Response to Issues – The City of Newcastle Council

21 Honeysuckle Drive, Newcastle – SSD 8019

**CONSTRUCTION VEHICLE
MOVEMENT PLAN**

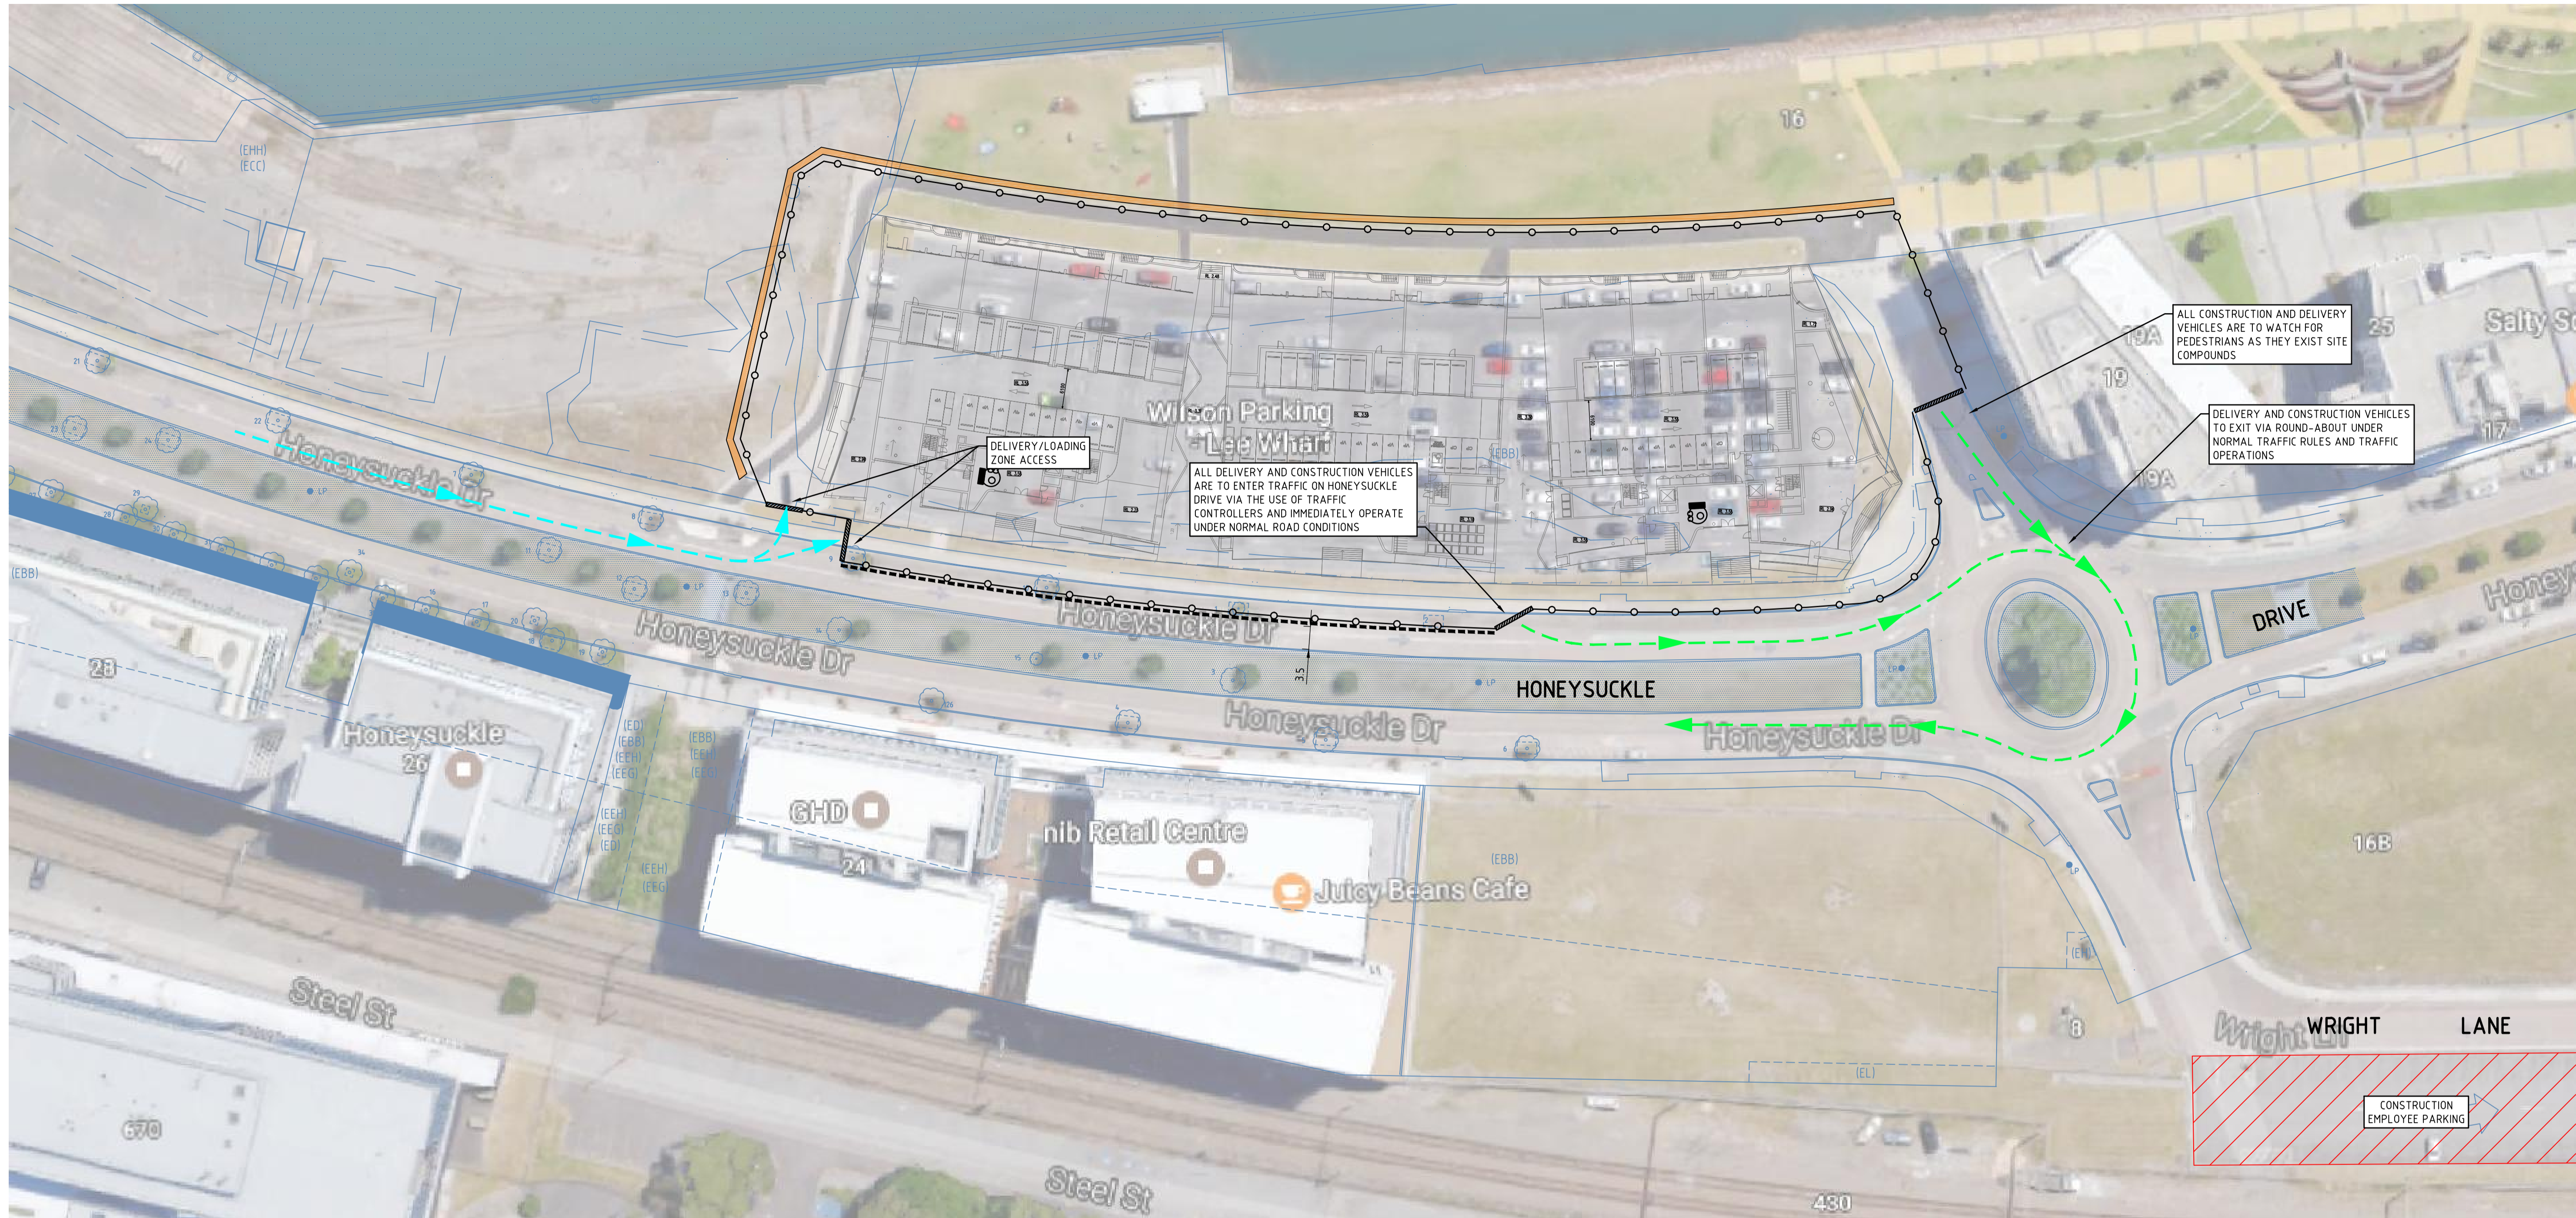
Matter	Particulars of Issues	Proponent Response	Attachment
Works Zone	<i>According to the submitted Traffic Assessment report prepared by SECA Solution, the development will be using the Honeysuckle Drive frontage as a "Works Zone" for the delivery of materials and building related matters. The existing bus stop may be impacted (or may require to be relocated) by the proposal. Accordingly, consultation will be required with the relevant stakeholders, including the private operators of Newcastle Transport and tourist transport companies. If the bus stop is to be relocated the approval of the Newcastle City Traffic Committee (NCTC) will be required.</i>	Given the number of stakeholders within the locality it is requested that this matter is addressed by way of condition.	N/A
Accessible Parking Spaces	<i>It is recommended clarification is sought from the applicant regarding the number of accessible spaces proposed.</i>	The proposed development provides a total of 16 adaptable spaces to ensure each adaptable apartment is allocated a space in accordance with Australian Standards.	N/A
